Application number: 2025/92331	
What is the application for?:	Variation of conditions 3 (use of floors) and 4 (operating hours) of previous pe
Address of the site or building:	Almondbury Working Mens Club, Southfield Road, Almondbury, Huddersfield, HD5 8RY
Postcode:	HD5 8RY

Proposed Rear Elevation

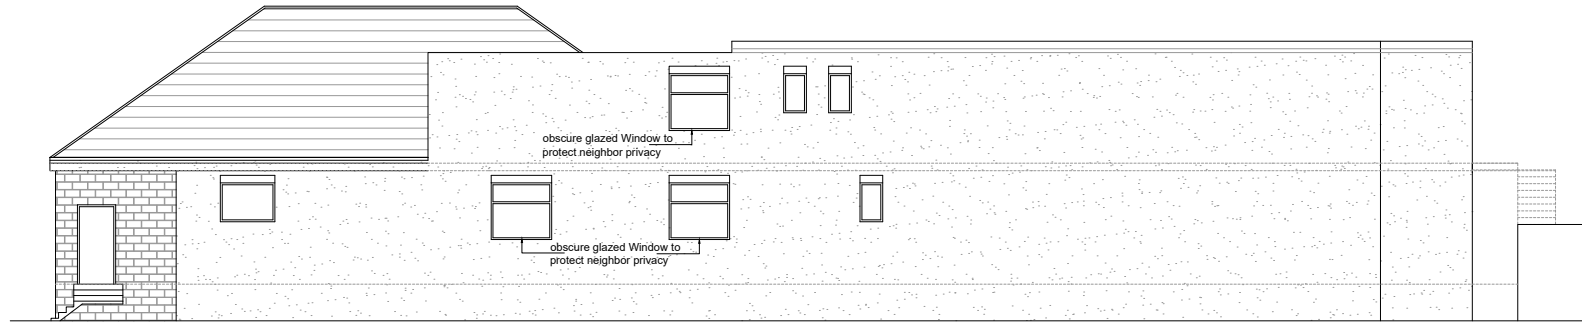
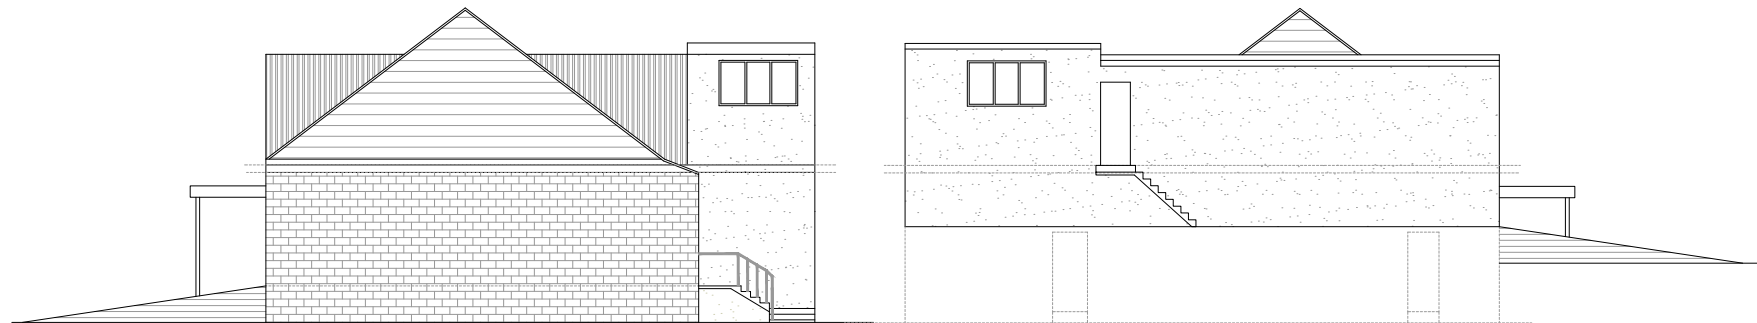
Type of comment: An objection	
Do you wish your comments to be published on the website anonymously?	<input type="checkbox"/> Yes
<p>On the original and updated plans the windows at the rear of the building are shown as 3 windows, however recently this has been altered to a doorway/2 windows onto a flat roof. What concerns us is that if this is to become a fire exit that the roof it goes onto might not be structurally sound for people to walk on and at the moment there is no way to get to ground level. If a staircase is installed to ground level it is into a small space to where there is already a fire exit from another room, and accessibility is limited. If it's not going to be a fire exit but somewhere people working there can go and sit outside, then they are able to look straight into the neighbouring houses and we would have no privacy in our gardens or living rooms. I have photos if any are required to substantiate this. The new plans for ground level windows at the back of the building will be looking straight into people's gardens and living rooms and again privacy is an issue.</p>
